"Southwold"
52 Crossbush Road
Felpham
W Sussex
PO22 7LU

Re: FP/312/17 HH

We wish to object to the above planning application, on two grounds:

Block Plan
Scale 1 : 5 0 0

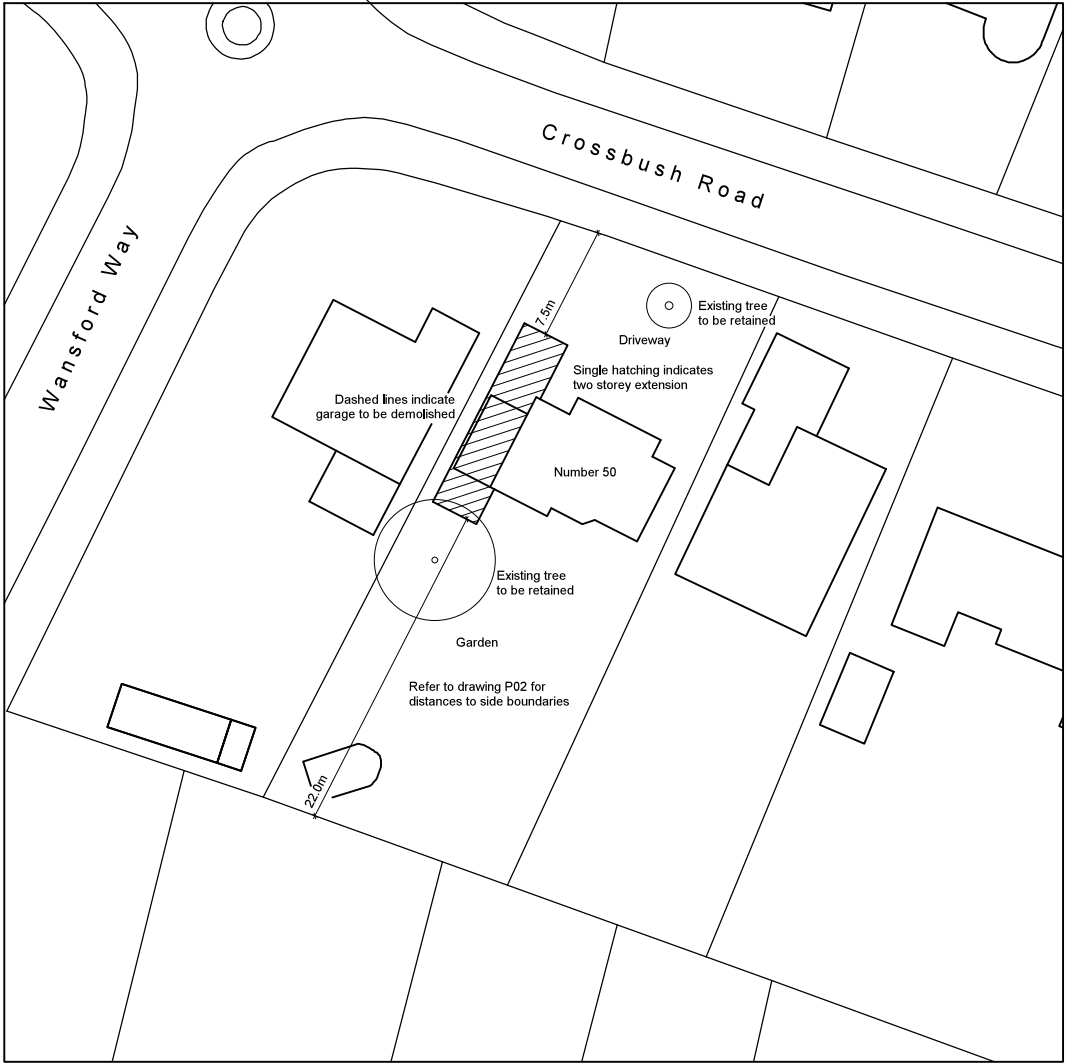
The plan of the front does not show the new "garage / shed" and will therefore impact on the capacity to park the owner's four vehicles on site.
